DOC19/1105145- 13; EF13/4404

**Mangoola Coal Continued Operations Project (SSD 8642)
Response to Submissions- Comments from the Environment Protection Authority (EPA)**

I refer to your email to the Environment Protection Authority (EPA) received 19 December 2019, requesting comments in relation to a Response to Submissions (RtS) document and seeking recommended conditions of consent in relation to the Mangoola Coal Continued Operations Project (SSD-8642) (the Project), located in the Muswellbrook local government area.

Figure 6-1 Noise and meteorological monitoring locations

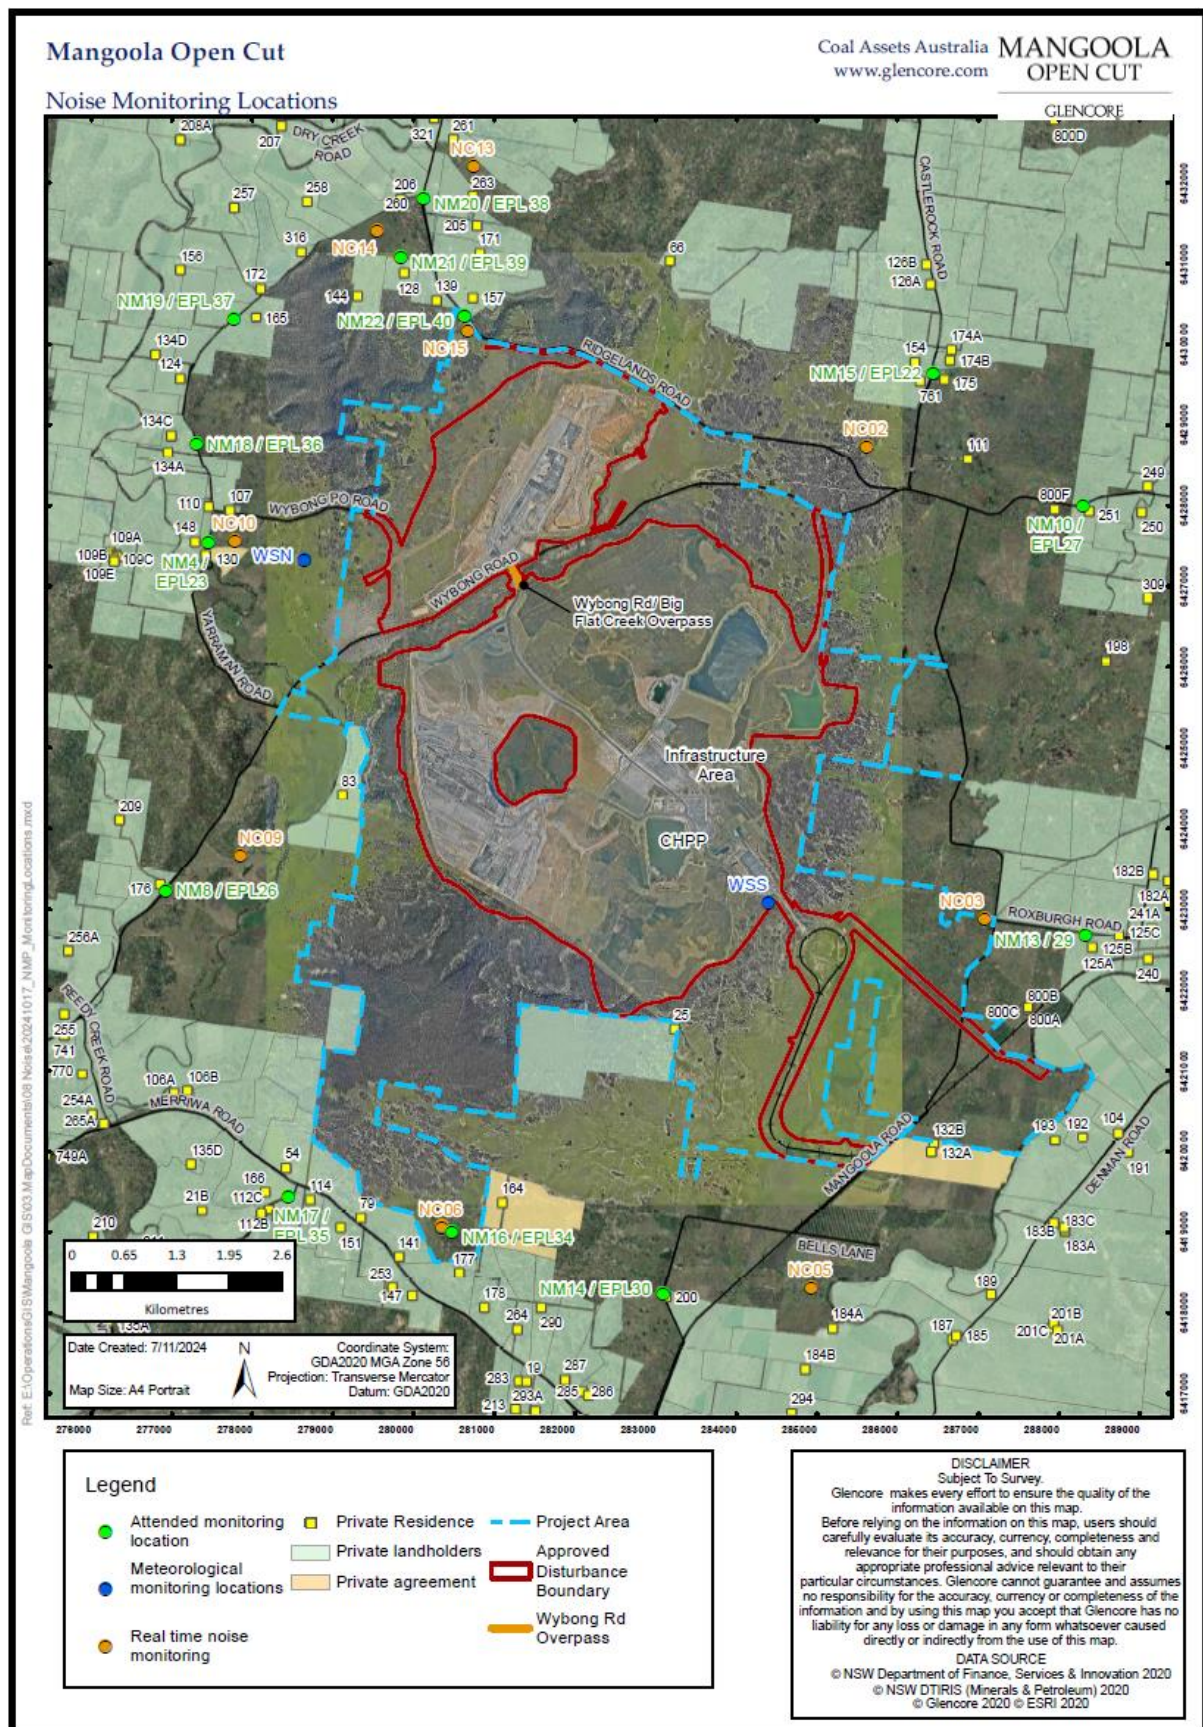
The EPA has recommended a condition of approval that requires noise monitoring at all impacted residences. However, the EPA would be willing to consider an alternative condition that requires monitoring only at representative locations based on Noise Assessment Groups, if the proponent can nominate appropriate monitoring locations.

Location	Noise Limits in dB(A)			
	Day	Evening	Night	Night
	L _{Aeq} (15 minute)	L _{Aeq} (15 minute)	L _{Aeq} (15 minute)	L _{AFmax}
144, 170, 171 & 176.	40	40	40	52
263, 109A, 109B, 109C, 109D, 109E, 109F & 134A.	40	39	39	52
25, 128, 154, 193, 261, 125A & 182B.	40	38	38	52
54, 79, 114, 141, 151, 192, 206, 321, 125C, 182A, 241A, 241C, 190 & 157.	40	37	37	52
165, 177, 106B, 104, 166, 178, 251, 253, 260, 112B, 183C, 184A, 147, 112A, 112C, 240 & 241B.	40	36	36	52
All other residential locations	40	35	35	52
